Re: Balloon Fiesta Park Sid Cutter's Pilots' Building (J08/D002)

The purpose of this resubmittal is to address concerns made in your letter to BHI dated August 20, 2014, and seek approval for Building Permit of the above referenced project. Your comments are restated and addressed as follows:

SITE DEVELOPMENT PLAN FOR BUILDING PERMIT  
SITE PLAN

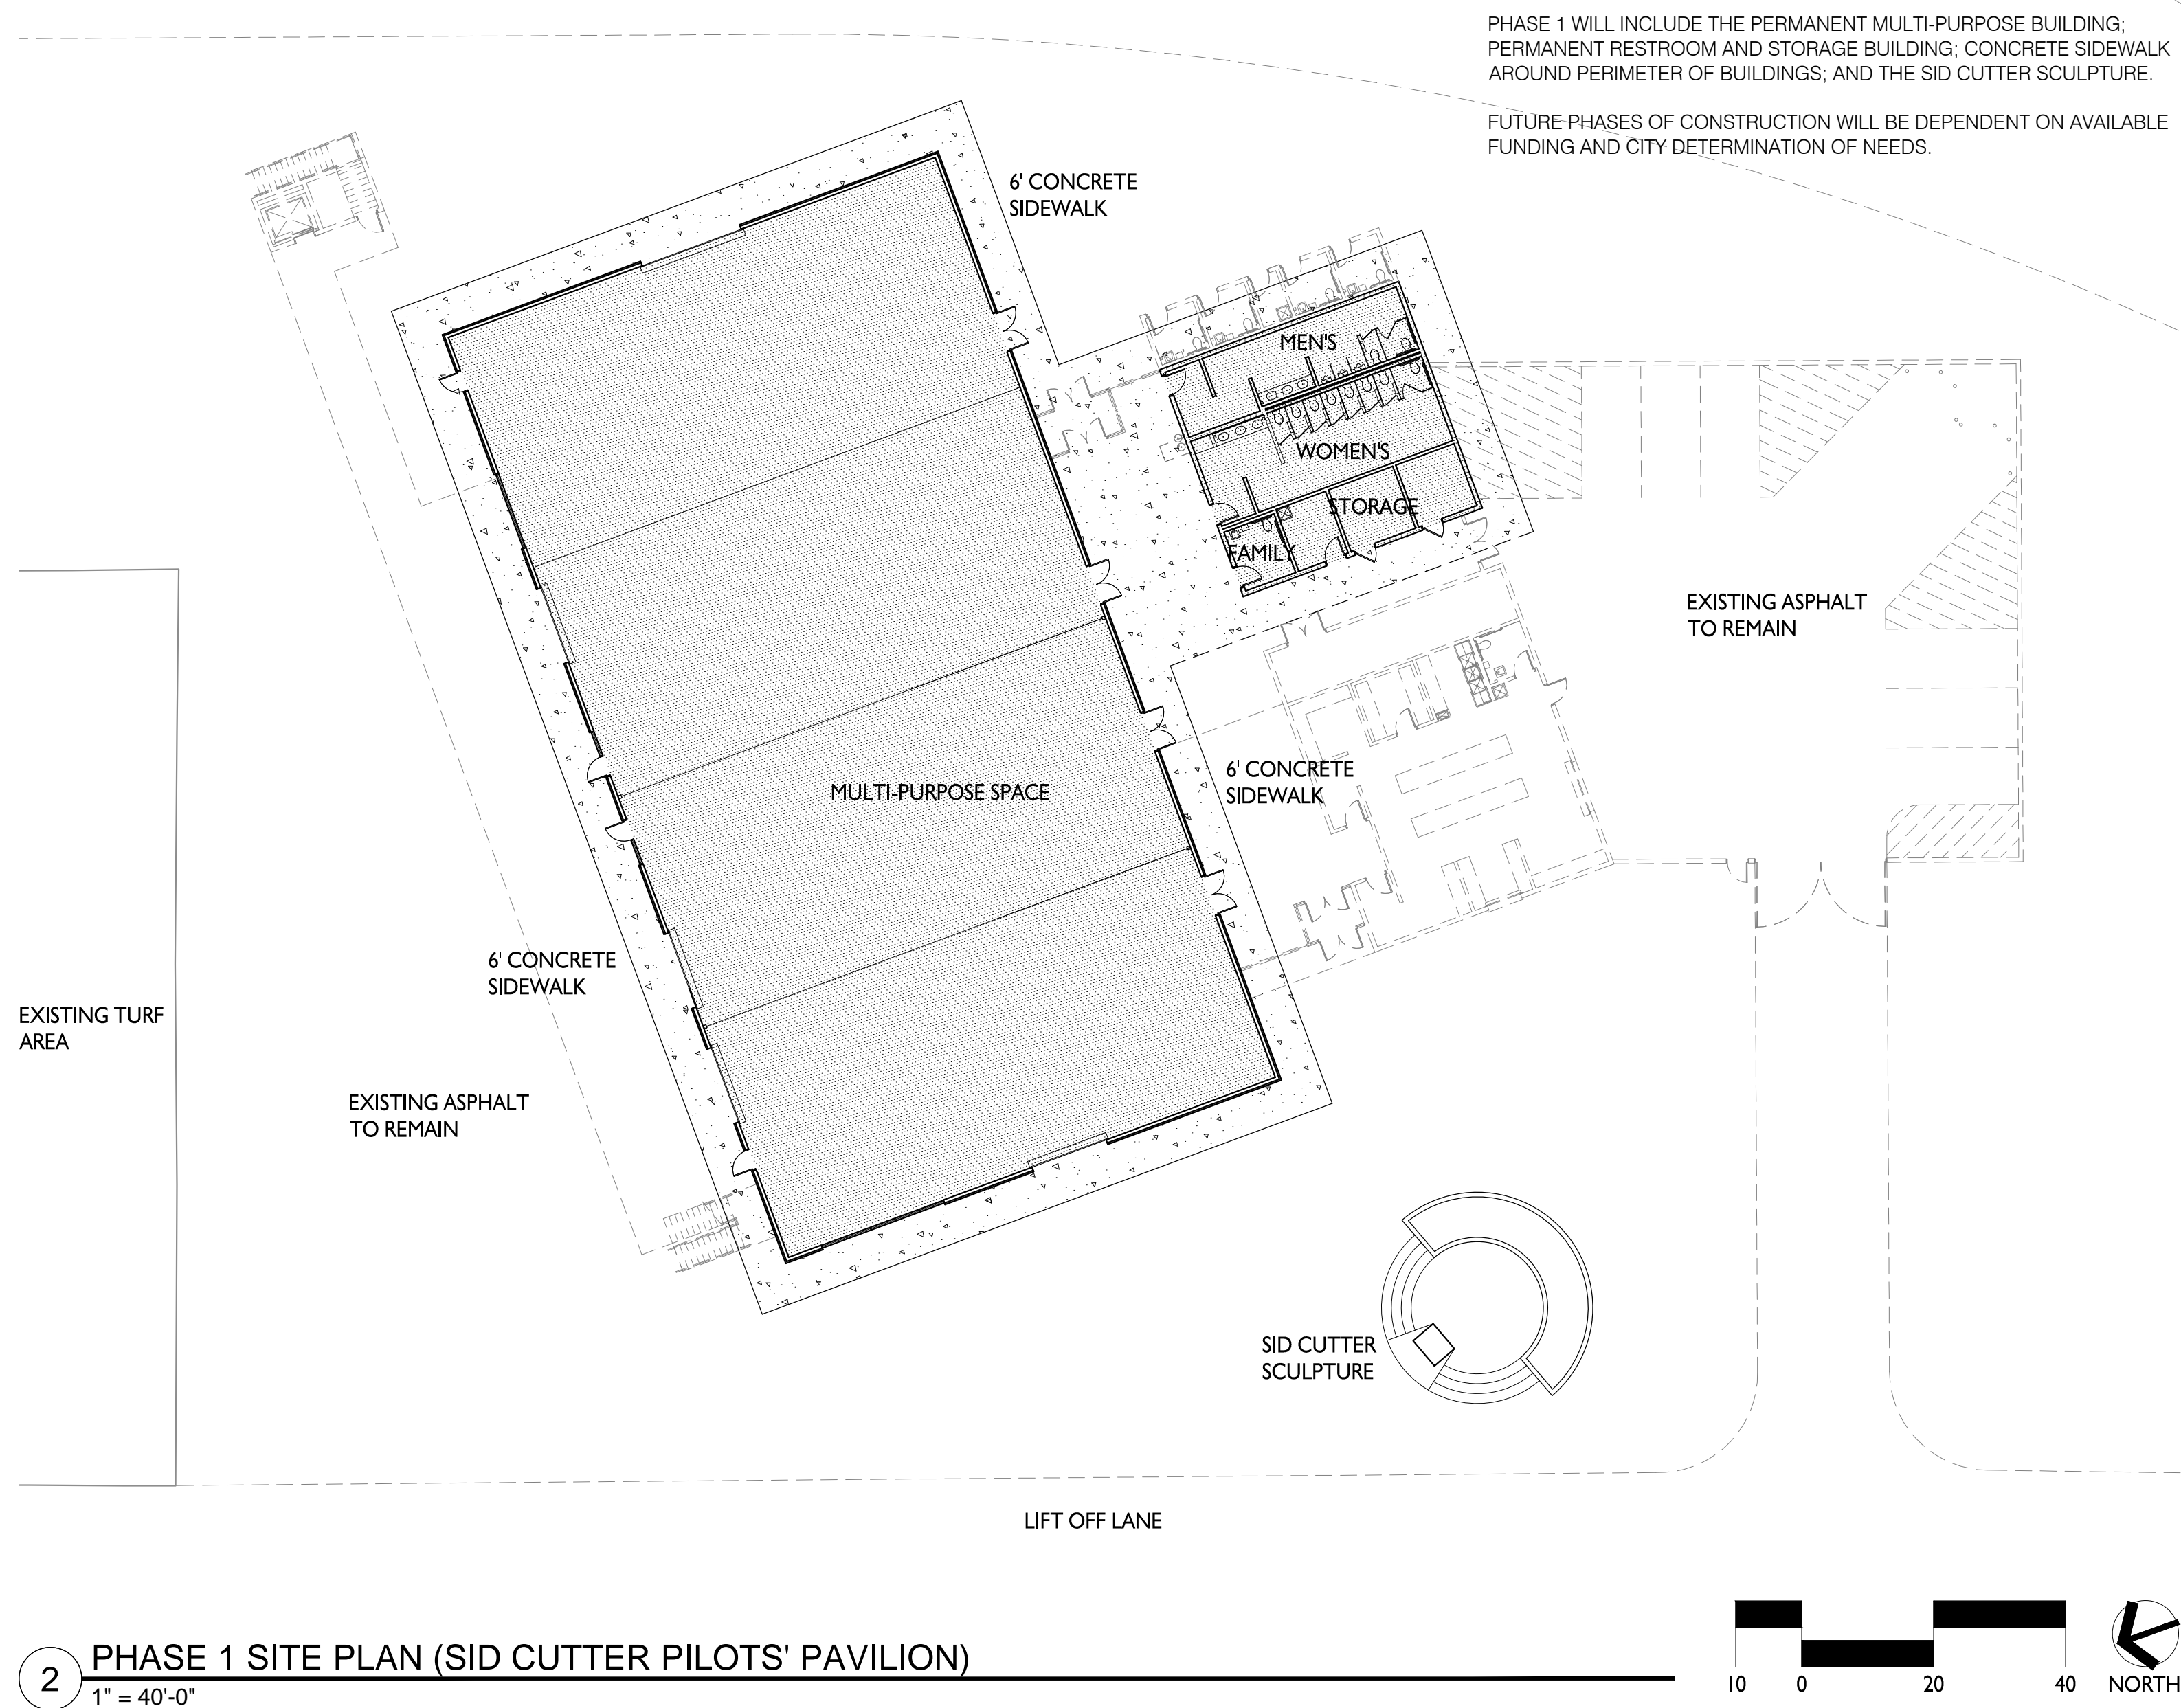
- The building is significantly different than what was approved for Site Development Plan for Building Permit. Submit for Administrative Amendment to the Site Development Plan for Building Permit and receive approval.

- As discussed, the layout shown was approved by DRB.
- On DMP-1, from the description of the existing conditions only 6.0 cfs is getting into the current storm drain system and the rest (12.34 cfs) overflows to the fields and eventually reaches the North Diversion Channel. For proposed conditions, 18.36 cfs is going into the existing storm system. Does the existing system have capacity for this additional flow? What are the existing flows in the existing two 30 inch, the 24 inch, and the 18 inch storm drains? Do they have capacity for the additional flows being contributed to them? Explain how you reached a flow of 25.90 cfs in SD7.
